Kings Park Metal Recovery and Recycling Facility Expansion (SSD-10396)
Request for additional information

I refer to the Response to Submissions (RTS) for the Kings Park Metal Recovery and Recycling Facility Expansion (SSD-10396). The Department has reviewed the document and notes there continue to be outstanding matters that need to be addressed.

Attachment 1 – Department's comments

Attachment 2 – Noise – Department's comments

Figure 3: Amended On-site Stacking Plan

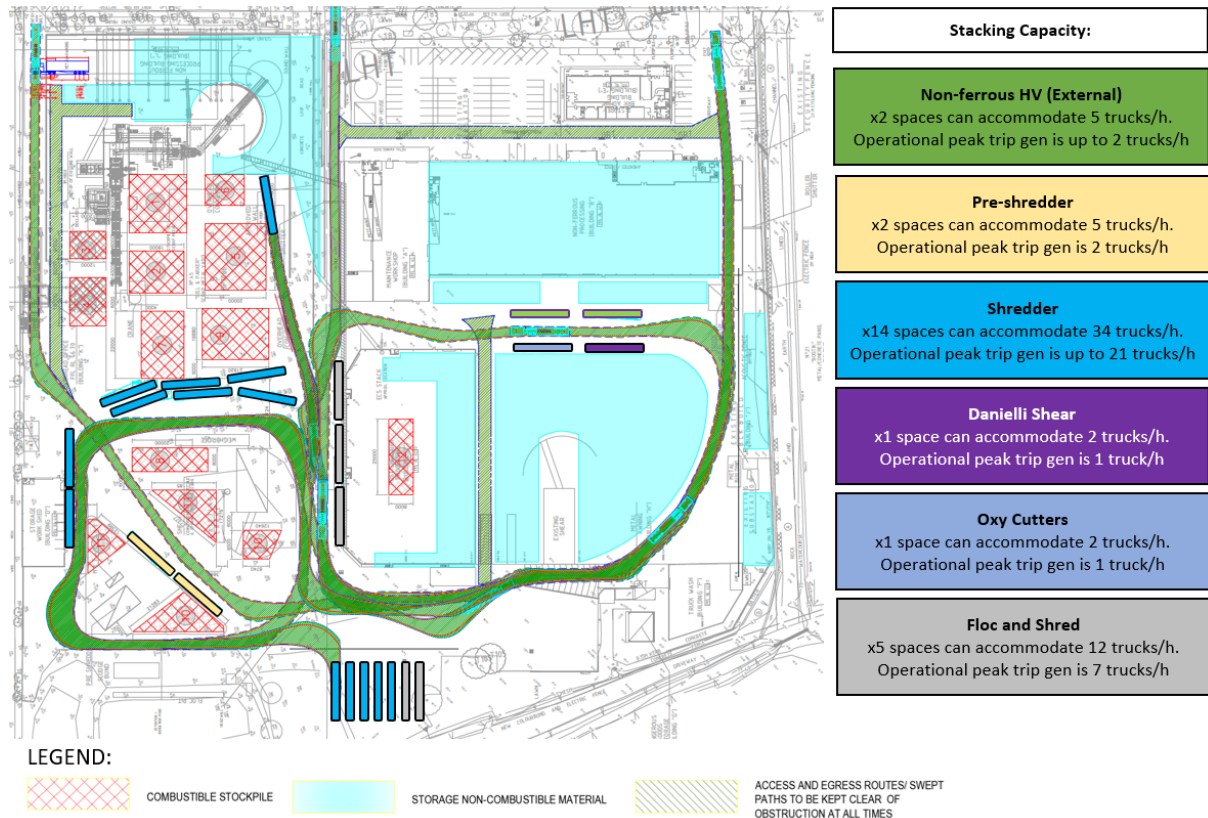
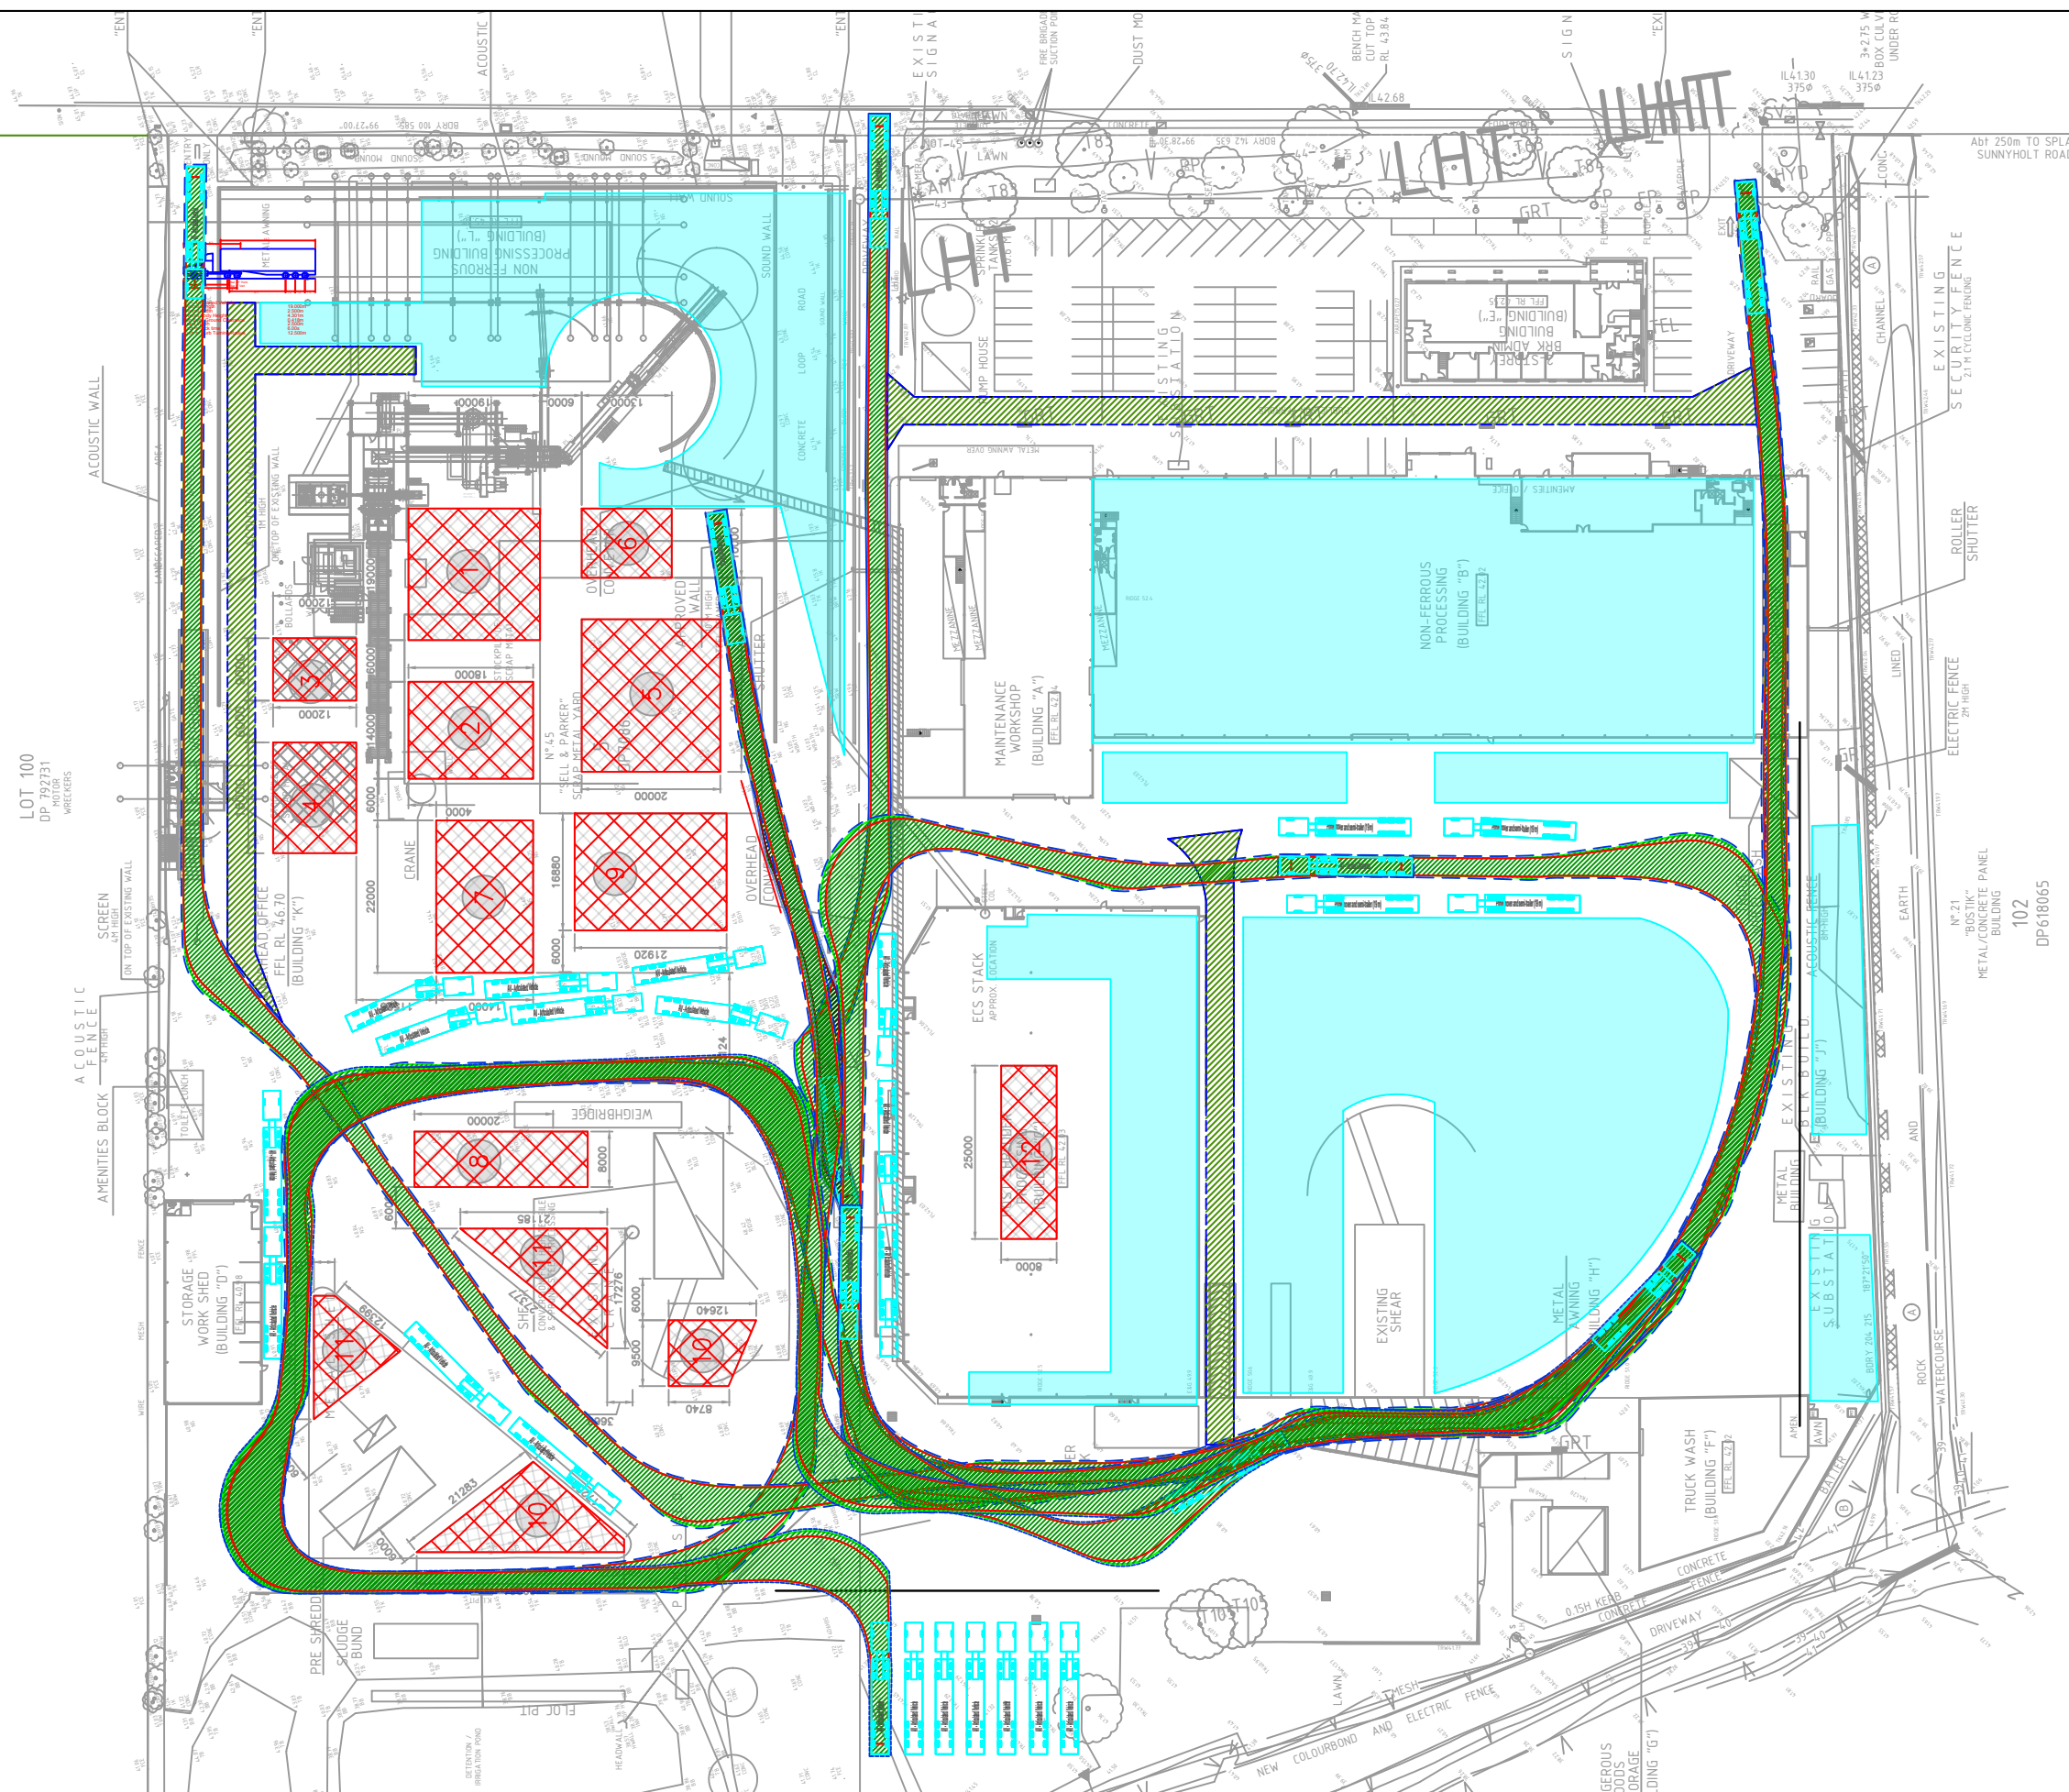
6. It would appear that Figure 6-1 in the Traffic Assessment (Appendix E of the EIS) shows heavy vehicles queuing/stacking in areas shown as stockpiles in the SP (Appendix G of the RTS). Please provide an amended Figure 6-1 that includes the proposed stockpile layouts and demonstrates there is sufficient room onsite for vehicle queueing.

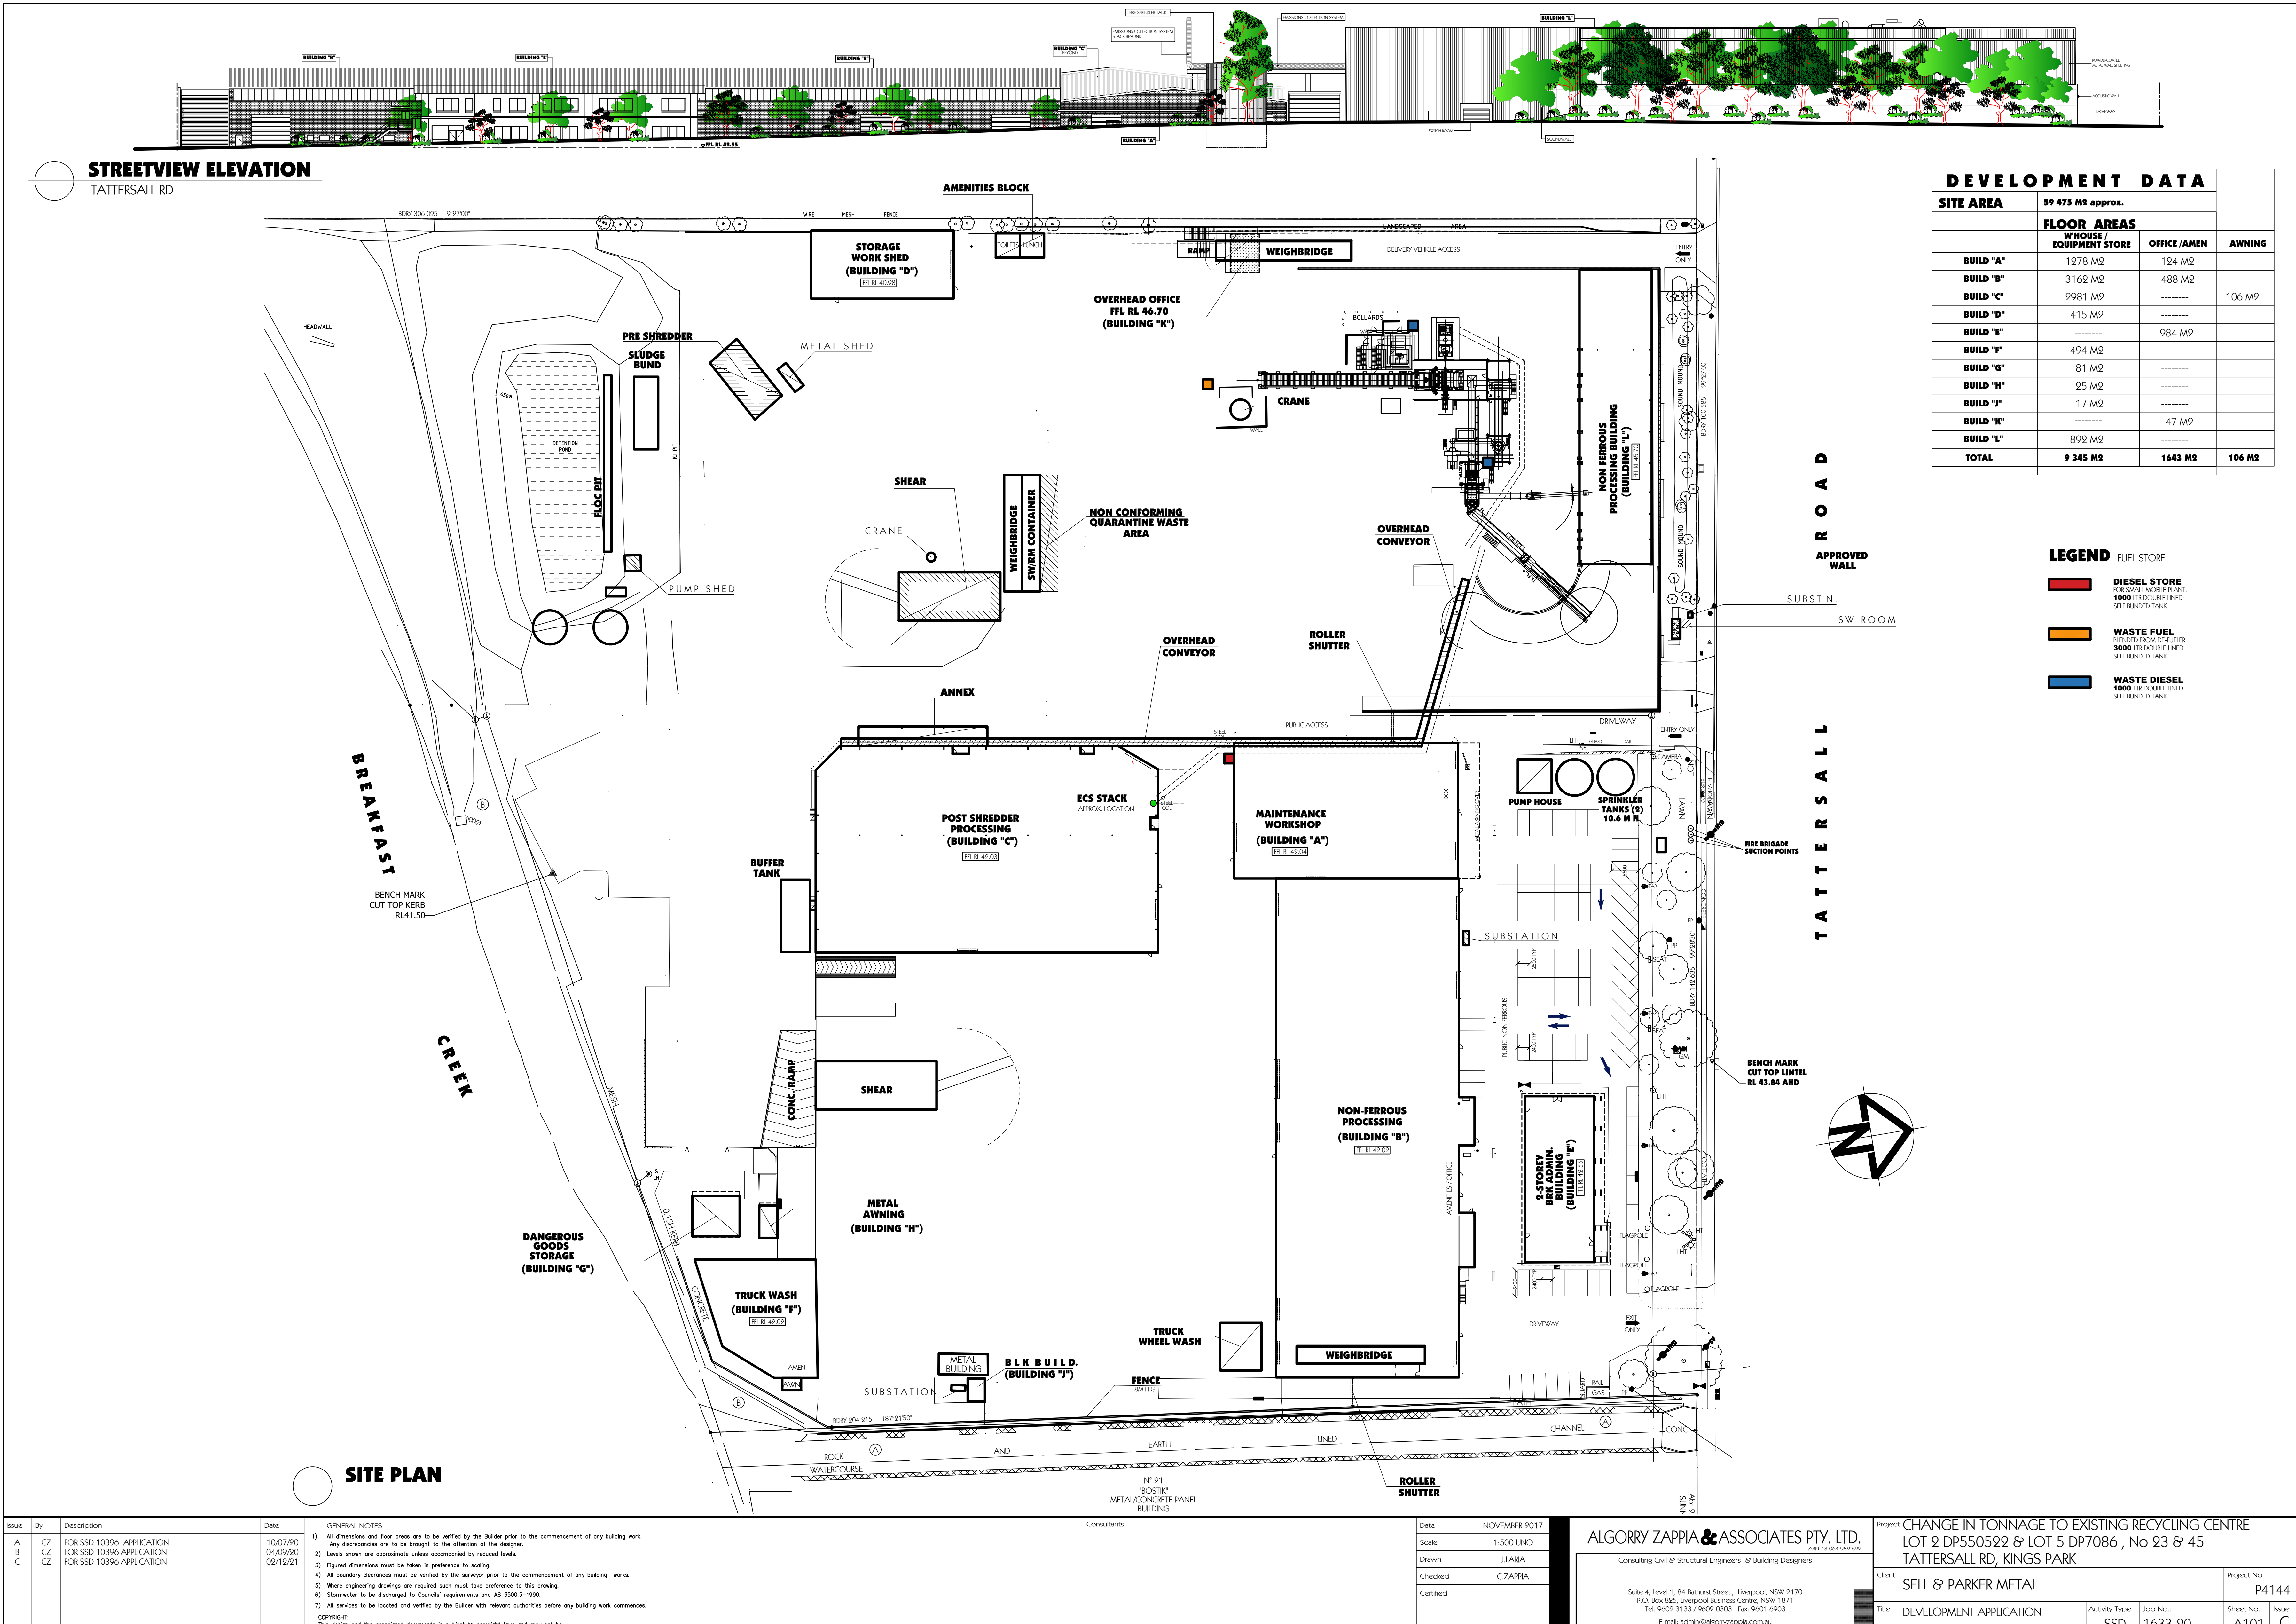
3. The SP provided as Appendix G in the RTS indicates that there would be no access into and through the Non-Ferrous Building (Building B) and limited access through the Post-shredder Processing Building (Building C). In addition, the area around the existing shear appears to contain one large stockpile. Please provide a revised SP that demonstrates how the site operates on a day to day basis including how access is maintained to the relevant buildings, how stockpiles are accessed by trucks and loaded/unloaded or moved around the site. Please include swept paths showing that trucks can access a stockpile as required.
